**From:** Sarah Fletcher <fletchsa1@gmail.com>  
**Sent:** Sunday, February 19, 2023 7:04 PM  
**To:** Andrew Leon; Jeff Thomas; Planning Commission; Design Commission  
**Subject:** Totally Against DSR22-014 Baskin Robbins Proposed 10-unit building

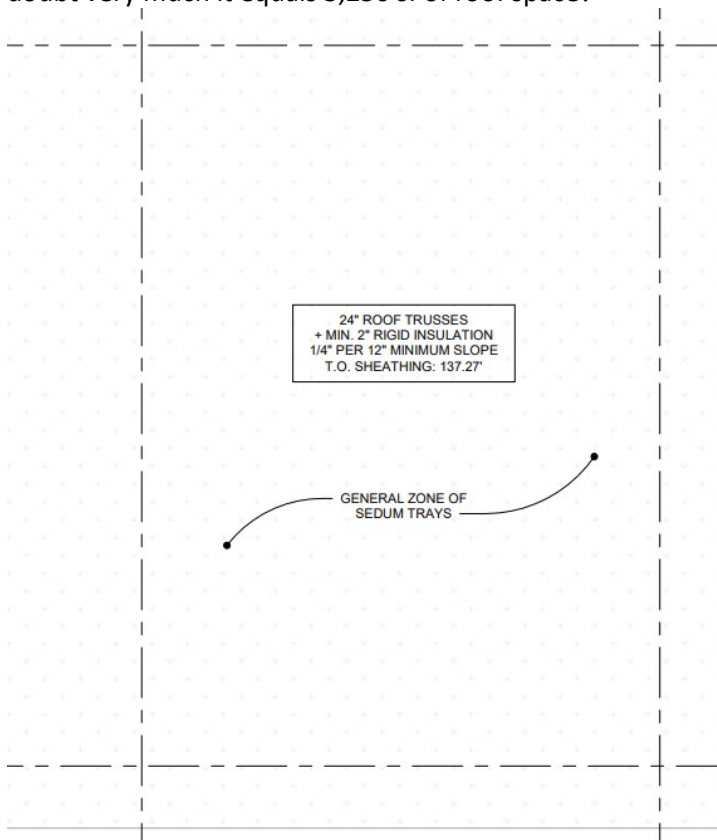
It says that 3,250 sf of sedum trays on the roof, but if you look at the plans on page 7, it does not show 3,250 sf of sedum trays, it shows a portion. And are you trying to say, that they can go across the road, buy a few trays of sedum and put them on the roof, and that is sufficient?

As I am a layman and don't know how to read plans, how much exactly is it showing? I

If you look at the plans, it has a section of the roof as for the sedum trays on a portion and not even on the whole roof, I doubt very much it equals 3,250 sf of roof space?
